An  
Bord  
Pleanála

**Board Direction**  
**BD-008703-21**  
**ABP-309907-21**

The Board decided to refuse permission, generally in accordance with the Inspector's recommendation, for the following reasons and considerations.

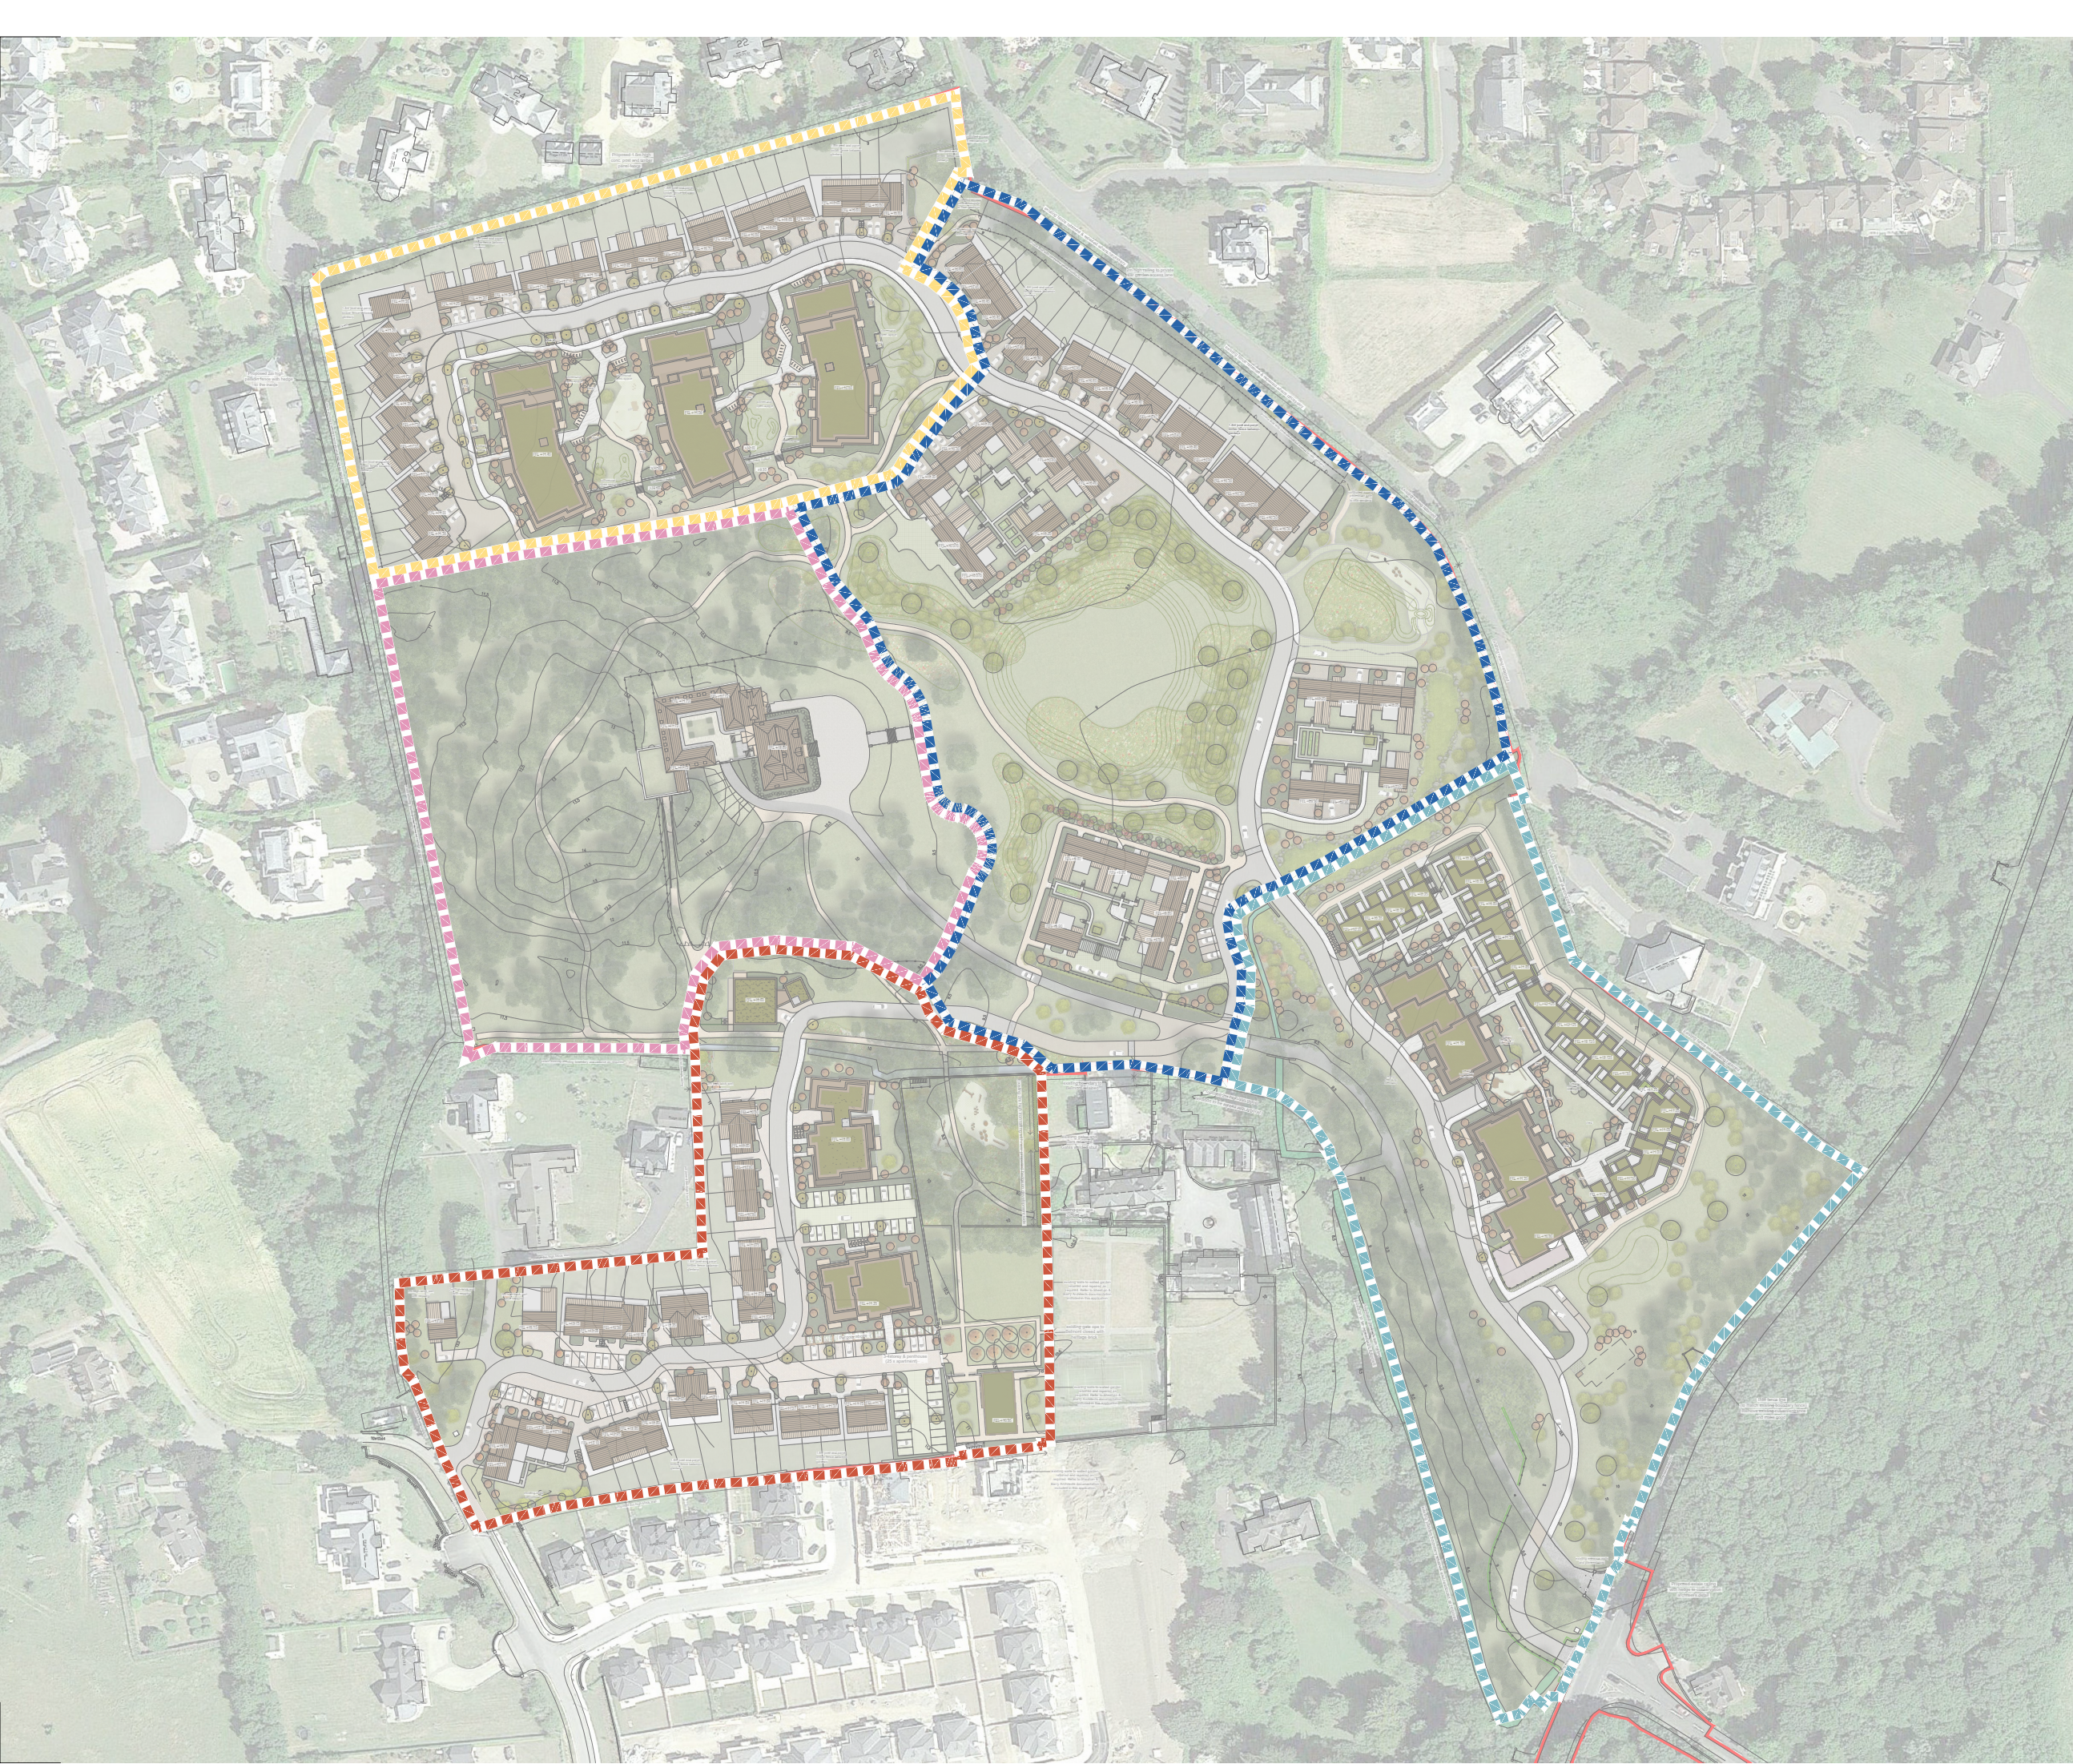
2. The proposed development is on a site characterised by woodland areas of heritage value and fronting onto the Dublin Road / Malahide Road which exhibits a sylvan character. These features are specifically identified under the Fingal Development Plan 2017-2023 as worthy of preservation. The proposed development would result in the loss of a significant number of trees, tree groups and hedgerows on the site, adversely impacting the integrity of woodland and canopy coverage across the site, to the detriment of the sites special and historical characteristics. As a result, the proposed development would be contrary to Local Objective 57, Objective PM64, Objective CH20, Objective CH21, Objective MALAHIDE 2 and Objective MALAHIDE 11 of the Fingal Development Plan 2017-2023. The proposed development would, therefore, be contrary to the proper planning and development of the area.

MALAHIDE ROAD/BACK ROAD UPGRADE PLAN
SCALE 1:200

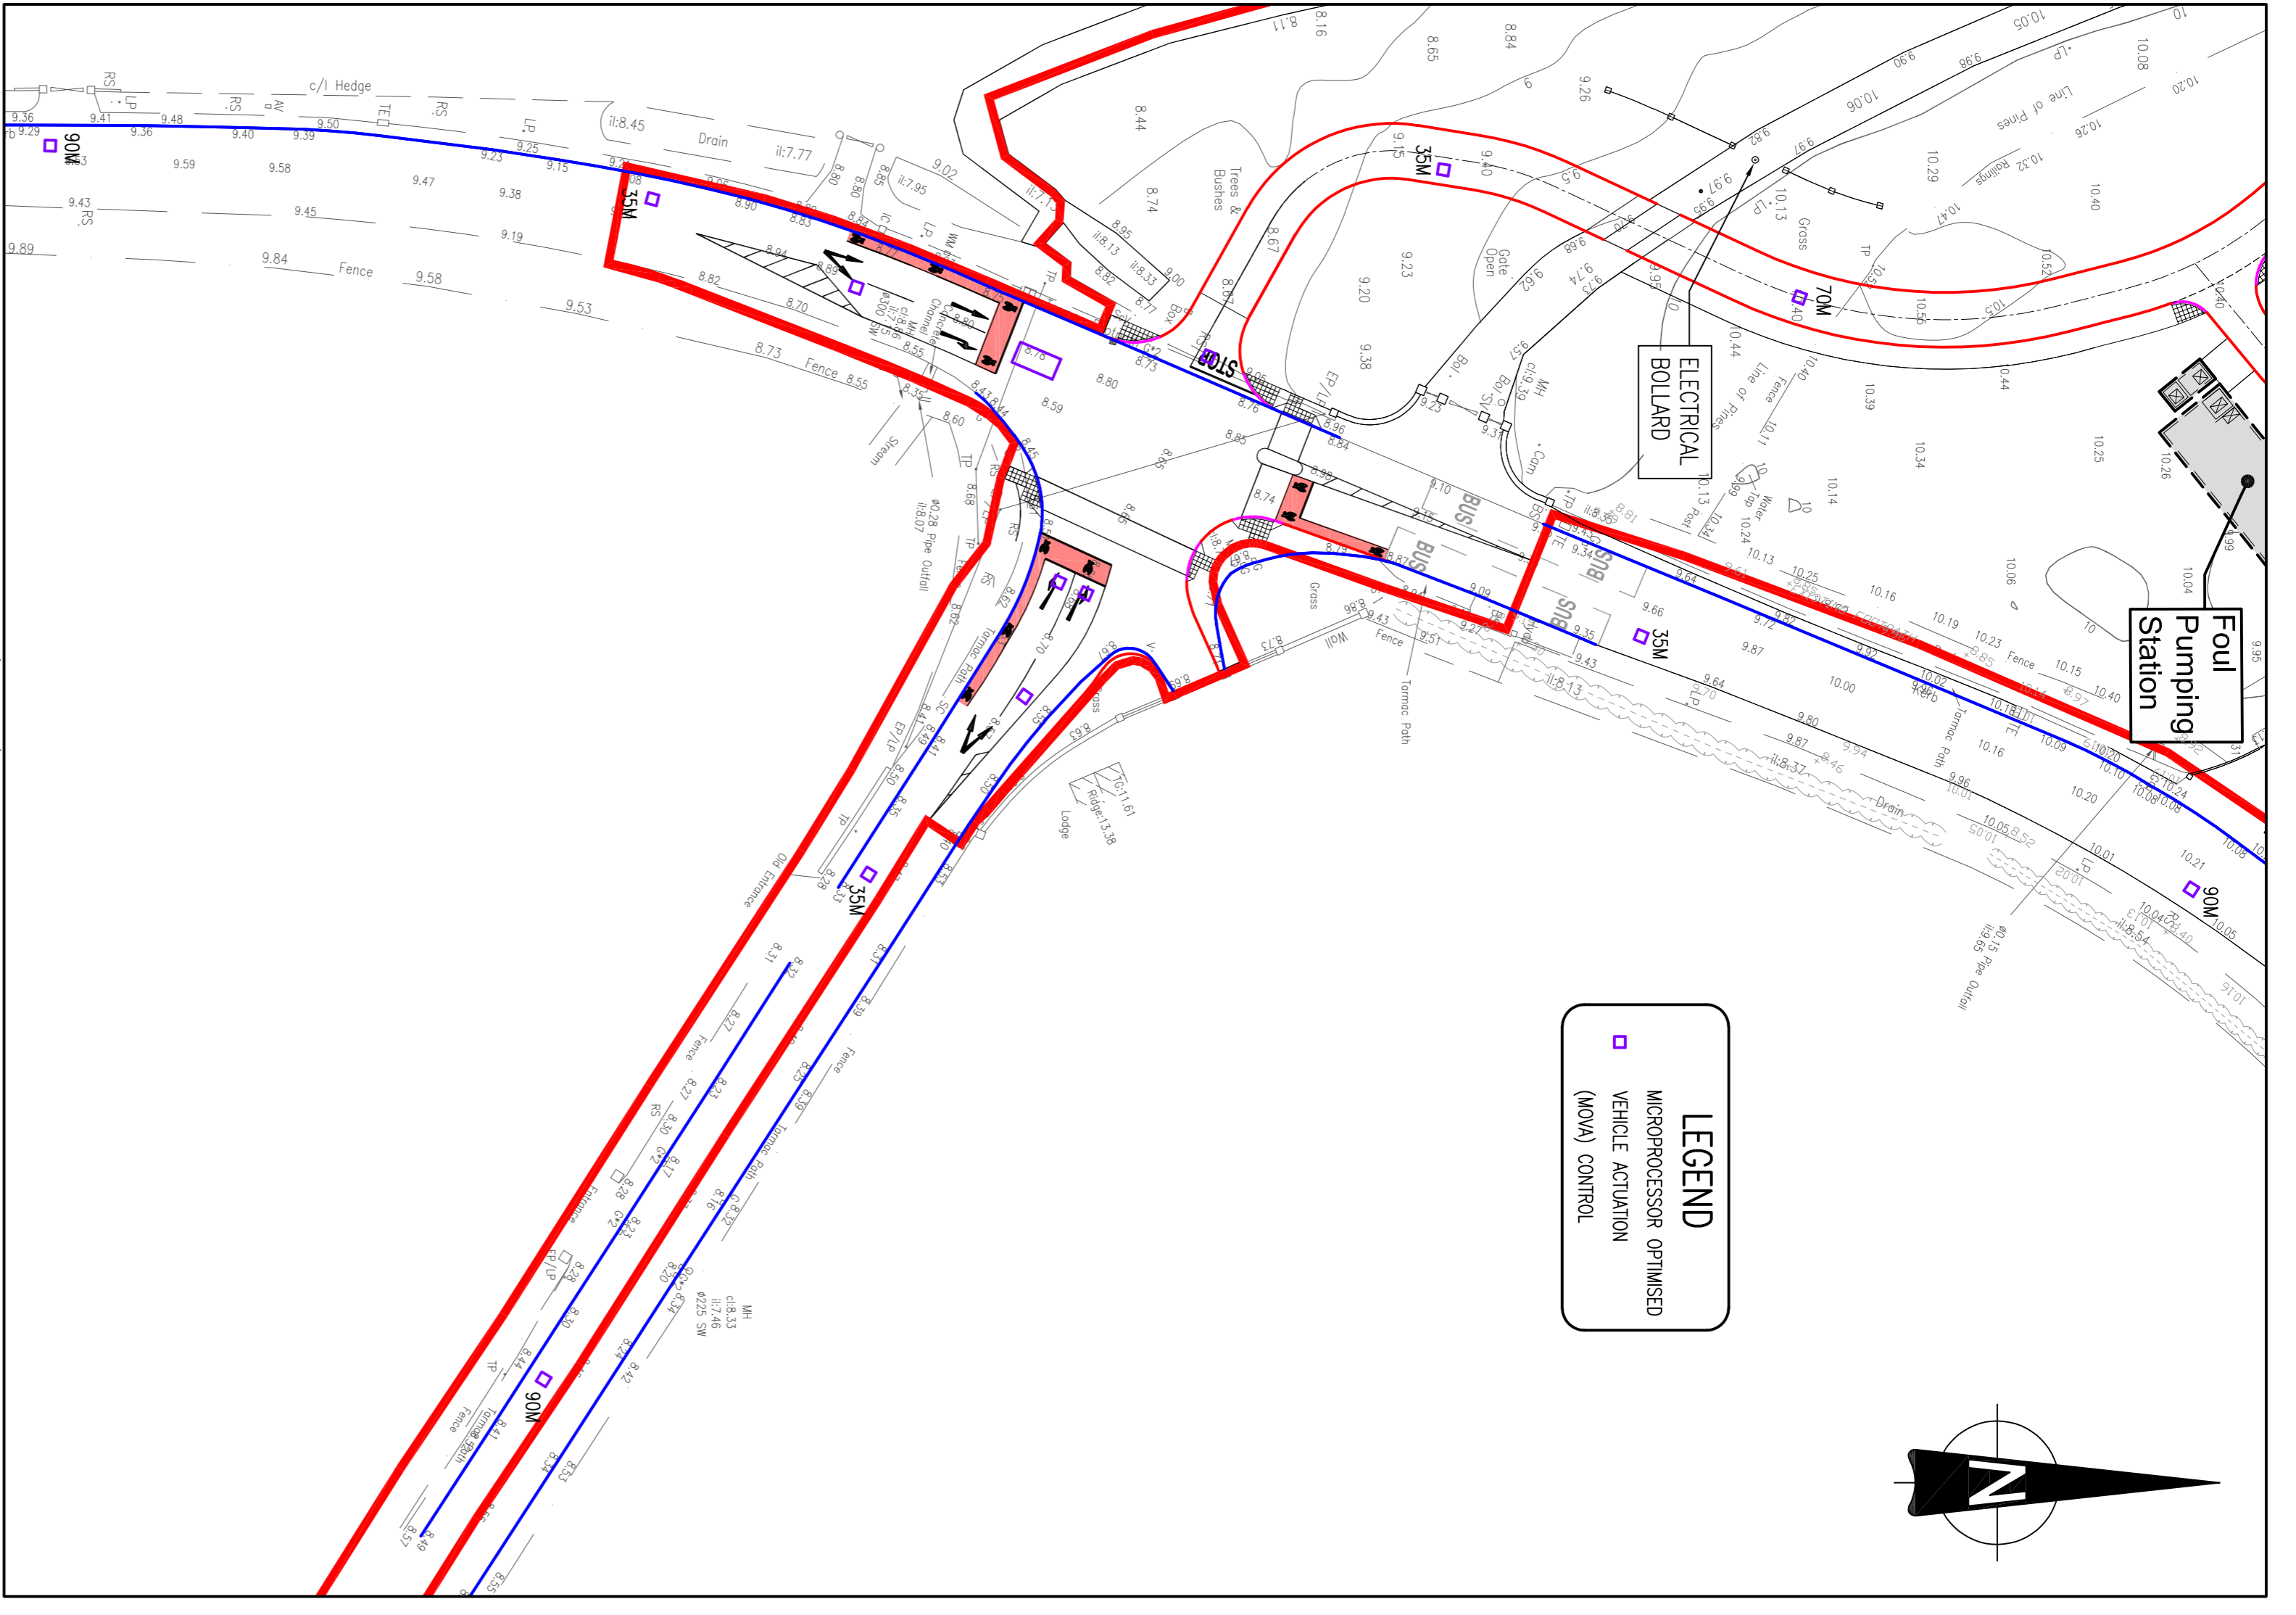
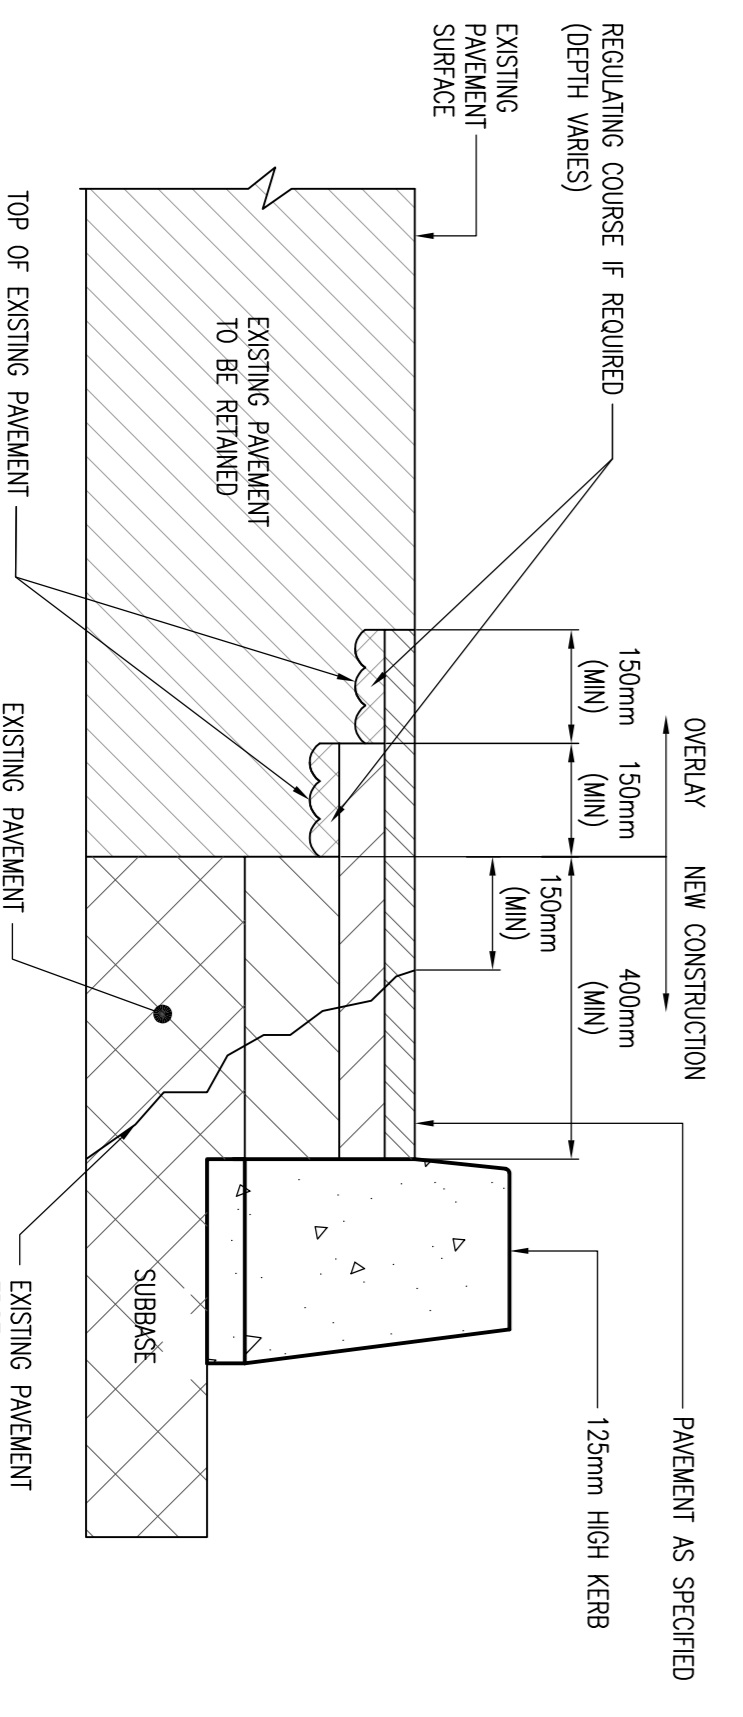
1. The proposed development would situate a new entrance from Dublin Road, both detracting from the visual prominence of the existing historical entrance to the site (a curtilage feature of Auburn House a Protected Structure RPS No. 448) and resulting in the removal of trees that contribute to a special character that is recognised as worthy of preservation in the County Development Plan. In addition, the proposed development would encroach upon the attendant grounds to the Protected Structure to the east, south and north: the situation of proposed houses to the east of Auburn House would reduce the openness of this historic landscape setting and conflict with the original alignment of the house to the Malahide Castle Demesne; the removal of trees in the south of the woodland surrounding Auburn House and construction of apartment block 7 would harm the integrity of the woodland and its function, informing the setting of the Protected Structure; and the location of blocks up to 6 storeys in height to the north of Auburn House has not been adequately tested visually and may be an inappropriate scale in the setting of this important and well preserved Protected Structure. The combination of these elements would significantly adversely impact the appreciation of the character and setting of the Protected Structure
